From: Simon Davis
Sent: 22 June 2021 11:16
To: Sparkes, Jessica [REDACTED]
Cc: Claire Potts <Claire.Potts@arun.gov.uk>
Subject: RE: *EXTERNAL: RE: Drove Lane, Yapton Y/49/21/RES

I thought it would be useful before this afternoon's meeting to set out all of our current issues with the scheme. Perhaps then we can go through these points at the Meeting. Please therefore see below the following summary of the points raised in the draft report that has been produced for Y/49/21/RES:

Drawing Title:
SITE LAYOUT
BOUNDARY TREATMENTS

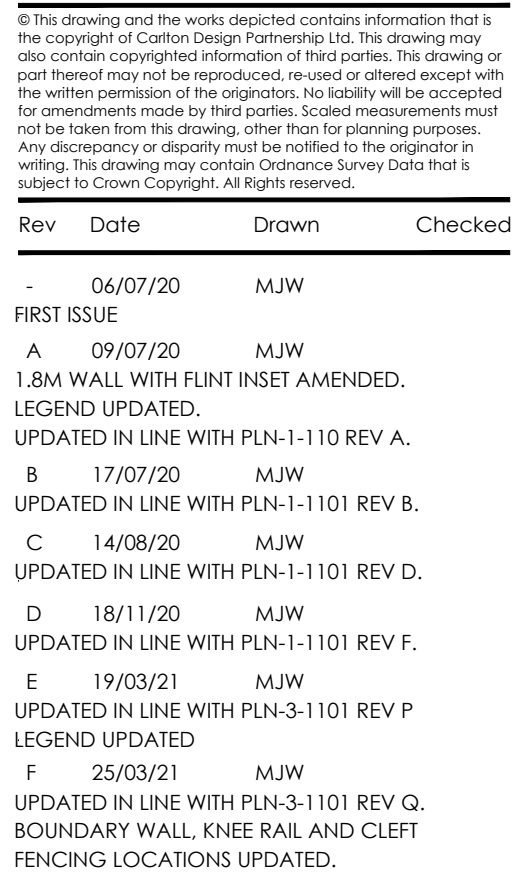
- The frontage treatment varies along the Link with a mixture of driveways, properties fronting directly onto the Link. This leads to a lack of definition between public and private spaces and a lack of defensible private space for properties. The presence of SuDS features in the Green Link also means that the pathways/cycle path through the Link are directly adjacent to the SUDs basins, which has resulted in the need for hard boundary edging. The perimeter blocks need redesigning to resolve these issues.
